**KIRKLEES METROPOLITAN COUNCIL
INVESTMENT & REGENERATION SERVICE**

DELEGATED DECISION TO DETERMINE PLANNING APPLICATIONS

Reference No:	2026/62/90613/E
Site Address:	Cross Lane Farm, 1, Common Lane, Emley, Huddersfield, HD8 9TB
Description:	Use of land for siting of shepherds hut for holiday let
Recommending Officer:	Danielle Cooper

Officer Report

Title:		
PROPOSED_SHEPHERDS_HUT_CLF_BP		
Scale: 1:200		
Digital File Name: CLF_PBP_001		
Drawing Number:	Sheet No.:	Status:
CLF_PBP_001	SHEETNO.1	REV_1

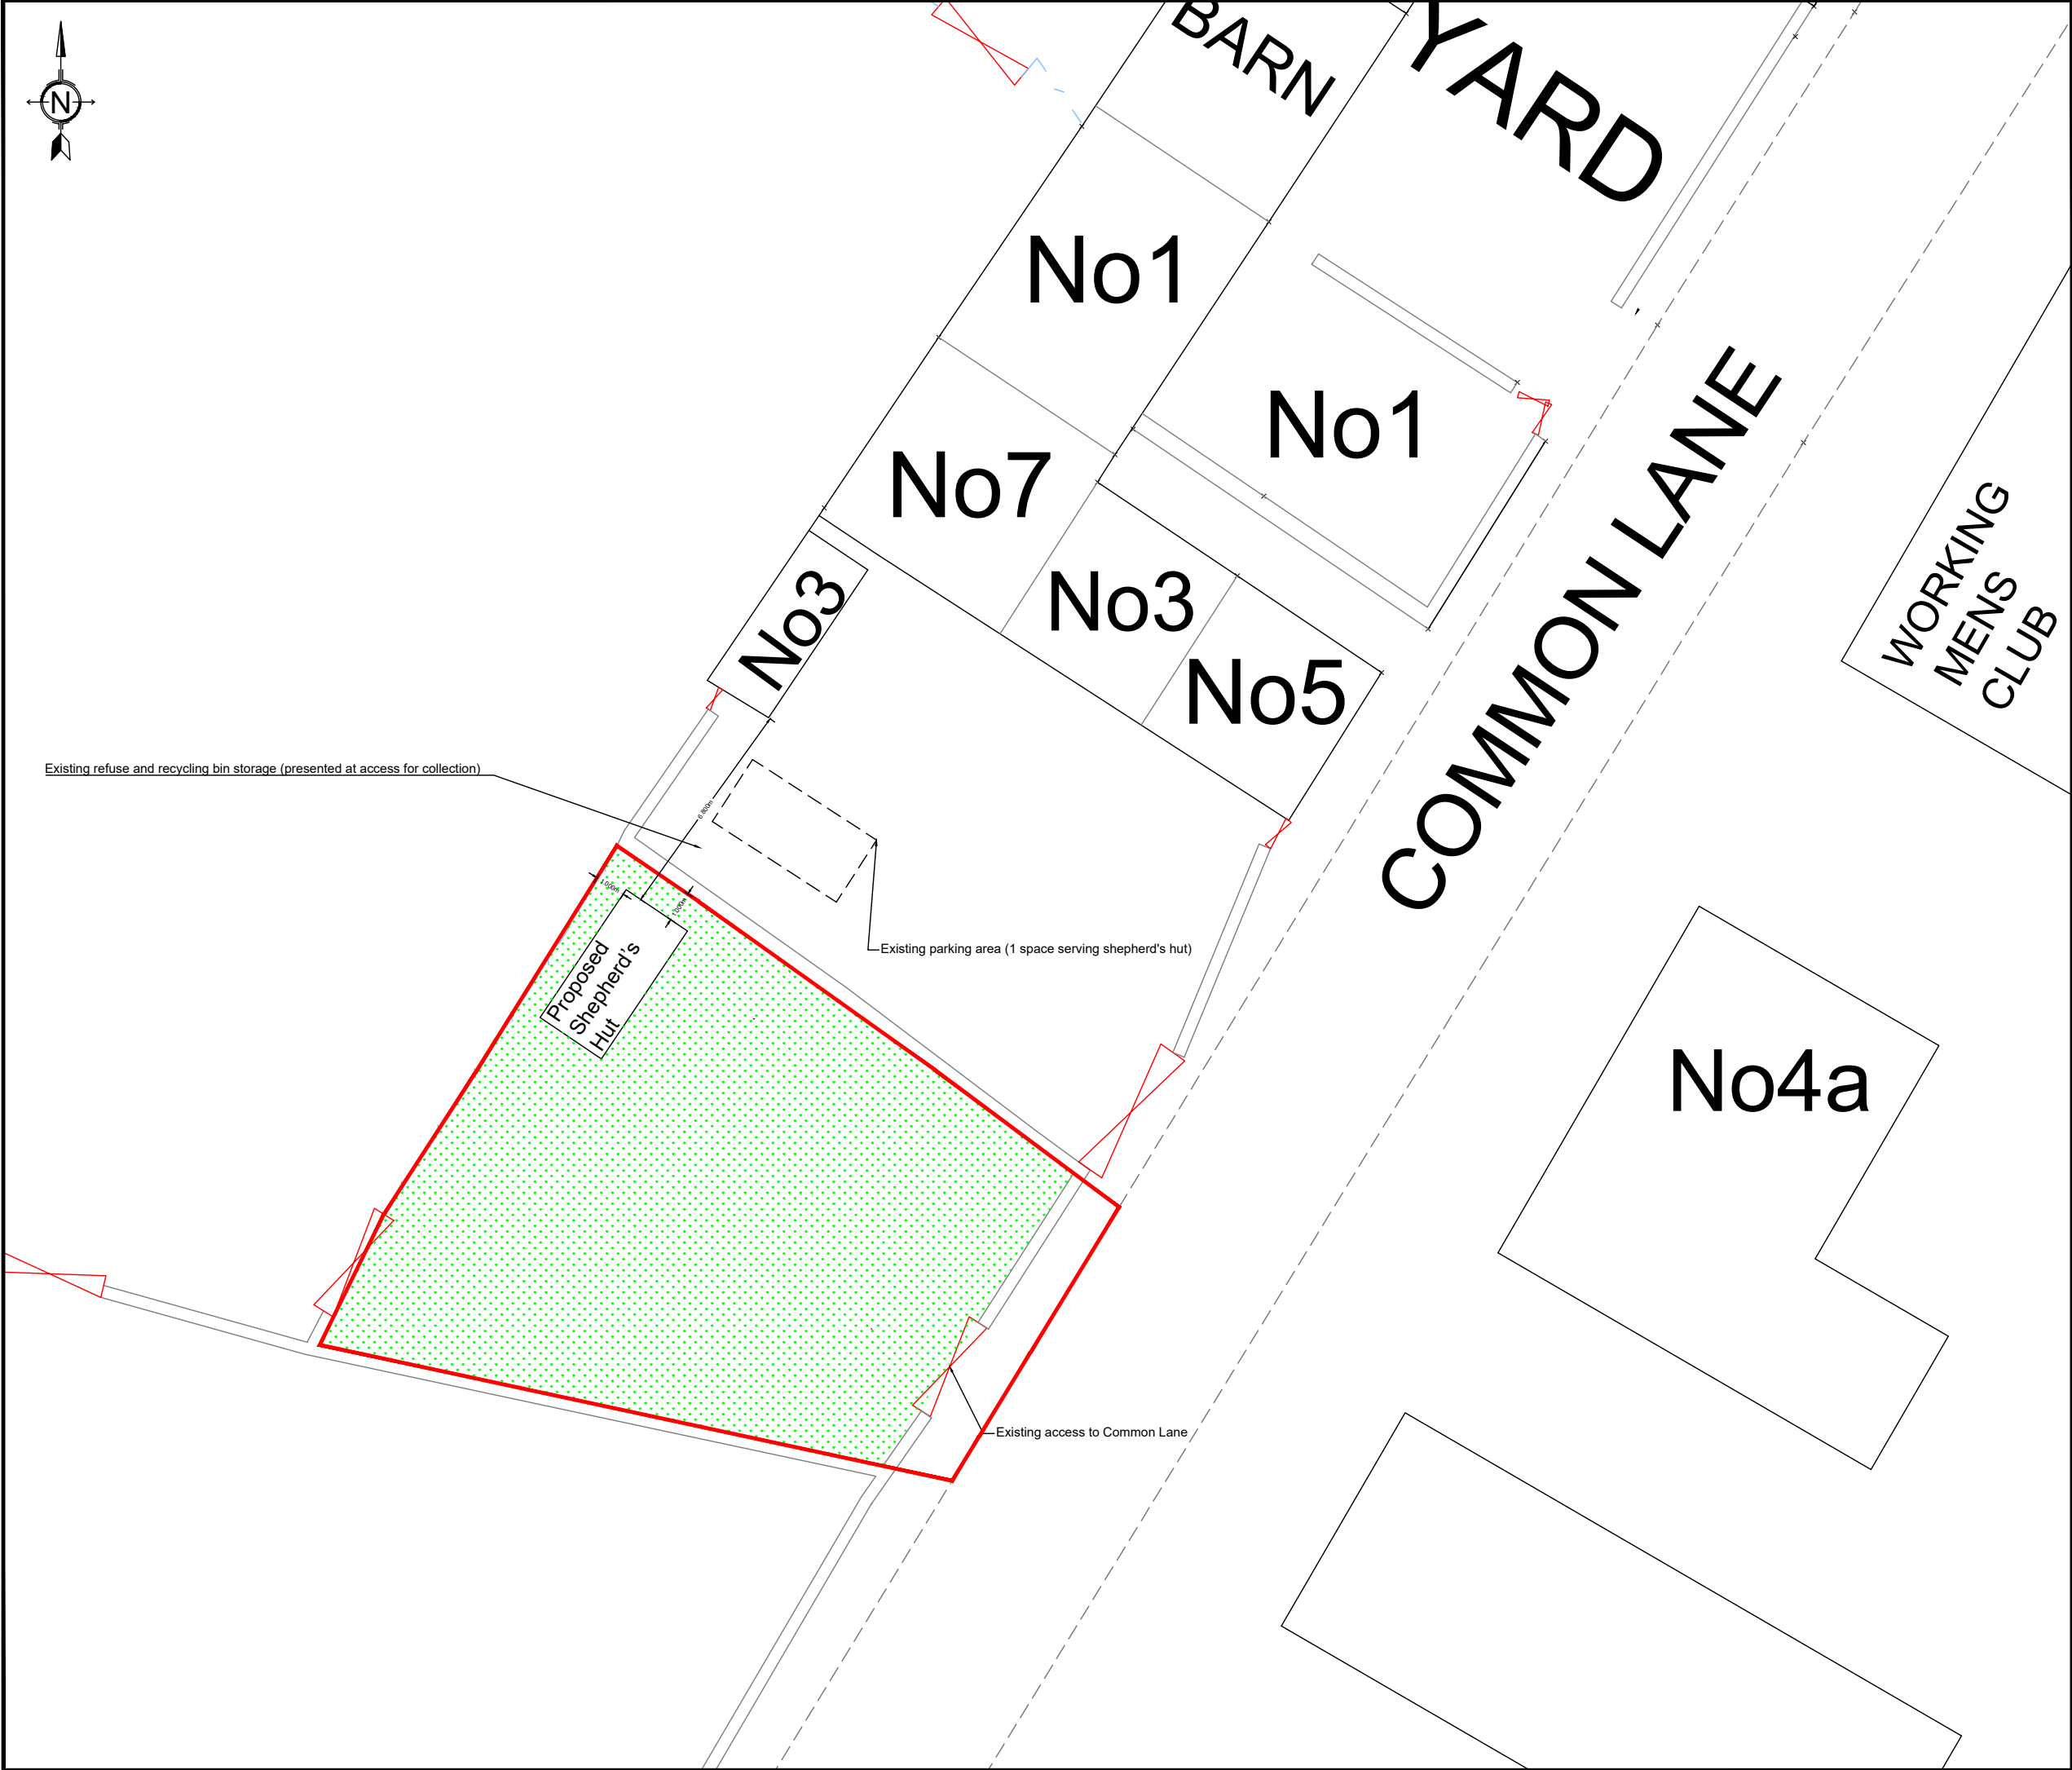
Officers requested further information regarding the alternative parking options, and where waste will be stored. The agent submitted a revised block plan and waste management plan and was considered acceptable. A noise management plan was also submitted. This will be discussed within the assessment of the report.

The site will be accessed from Common Lane and one car parking space is to be provided within the existing shared courtyard. The land in question is owned by no.1 Common Lane and is already surfaced. The proposed on site parking space is located within blue line boundary plan. Given the modest scale of the development, the proposed access and on site parking provided is considered acceptable, raising no concern to highway safety.

One car parking space would be provided in the existing hardstanding area at Cross Lane Farm.
